DRB Project Number: 2021-005482  
2040 Gibson Blvd. SE

SUBJECT: Sketch

**REQUEST:** DEVELOP LOT C-1 OF LOVELACE HEIGHTS ADDITION INTO A DRIVE-THRU OIL CHANGE FACILITY

**Project Name:** Gibson-drive through oil change facility

LOT C1	
PARCEL AREA	0.422 AC
PARKING	7
BUILDING	1,432 SF
LOT C2	
PARCEL AREA	0.758 AC
PARKING	34
BUILDING	2,600 SF

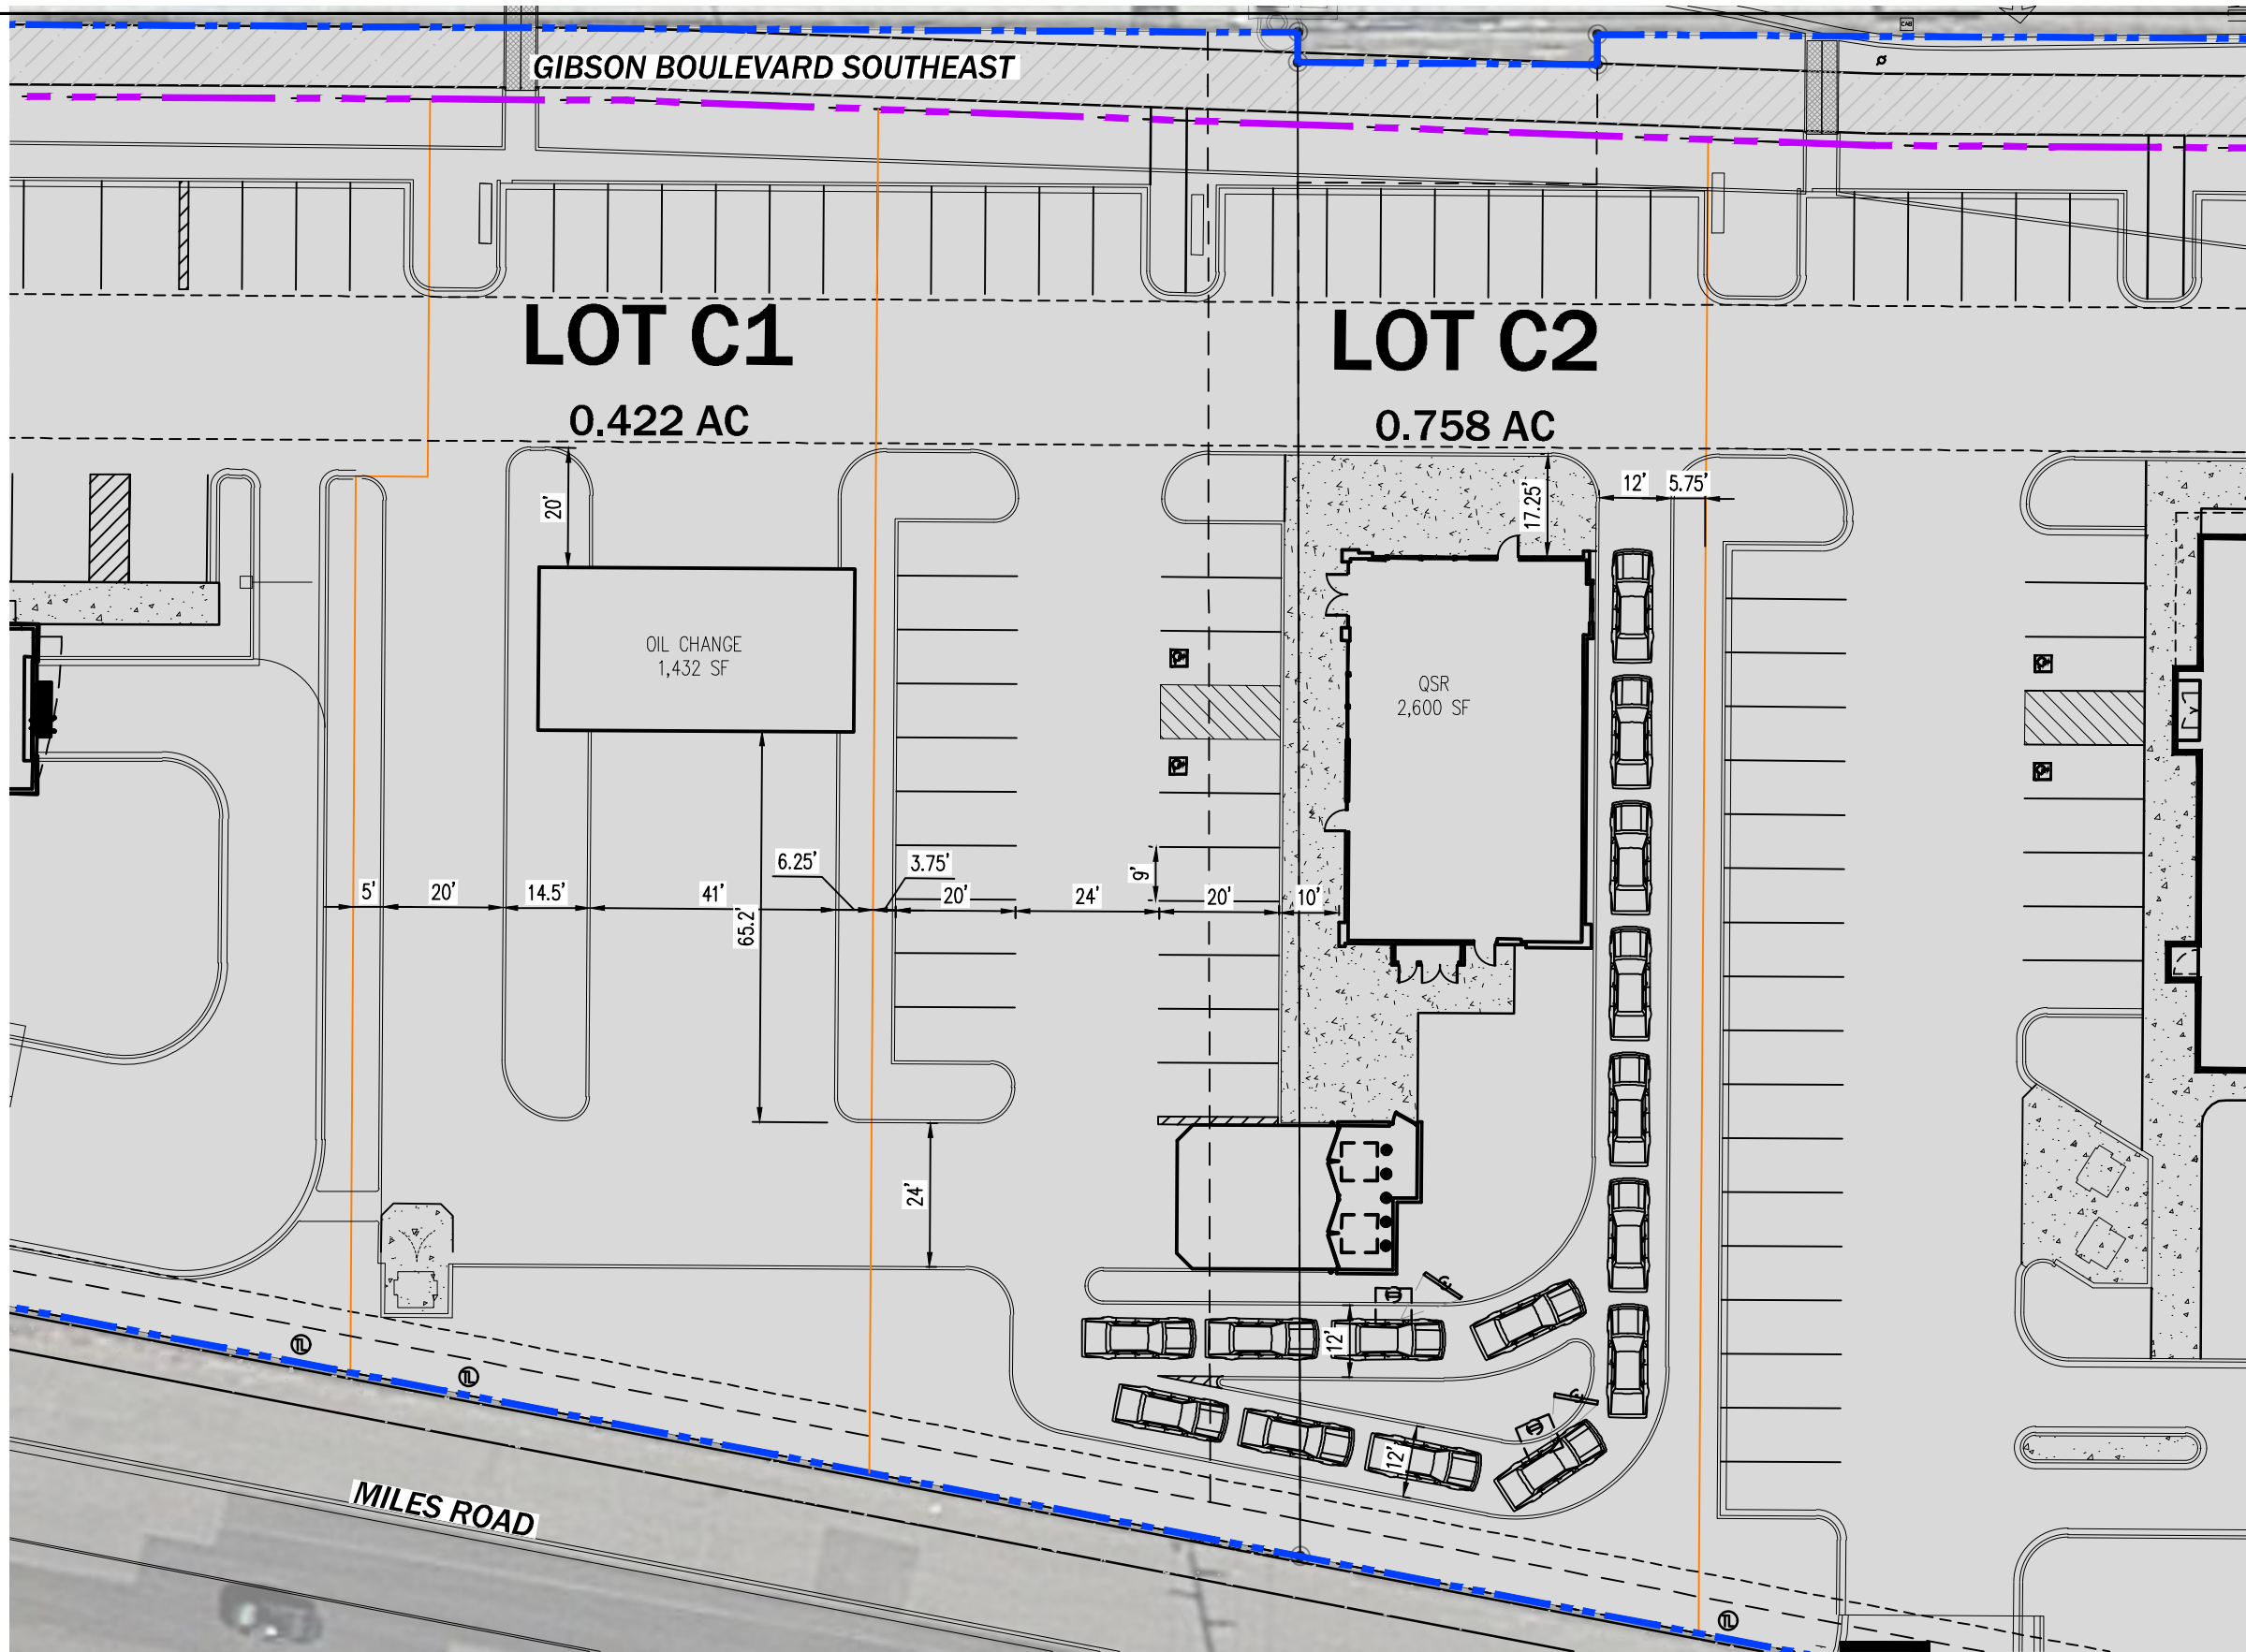
1. Please call out the cross-lot access easement for all lots on the plat.
2. An approved TCL will be required prior to site plan.

- This Sketch Plat which includes Lot C-1 proposes six parking spaces. Is there any intention for external lots to utilize the six proposed parking spaces? If so, a Shared Parking Agreement would be necessary for the external lots to utilize the six proposed parking spaces.

- According to this Sketch Plat, the proposed development on Lot C-1 will not have direct access to roadways the subject property is located along (Gibson Boulevard and Miles Road), and will require shared access from Gibson Boulevard and Miles Road through external lots to the subject property. The Plat approved by the DHO on April 12, 2023 features a note noting that Cross Lot Access Easements have been granted. **Please confirm that these easements provide access to the subject property to/from Gibson Boulevard and Miles Road.**
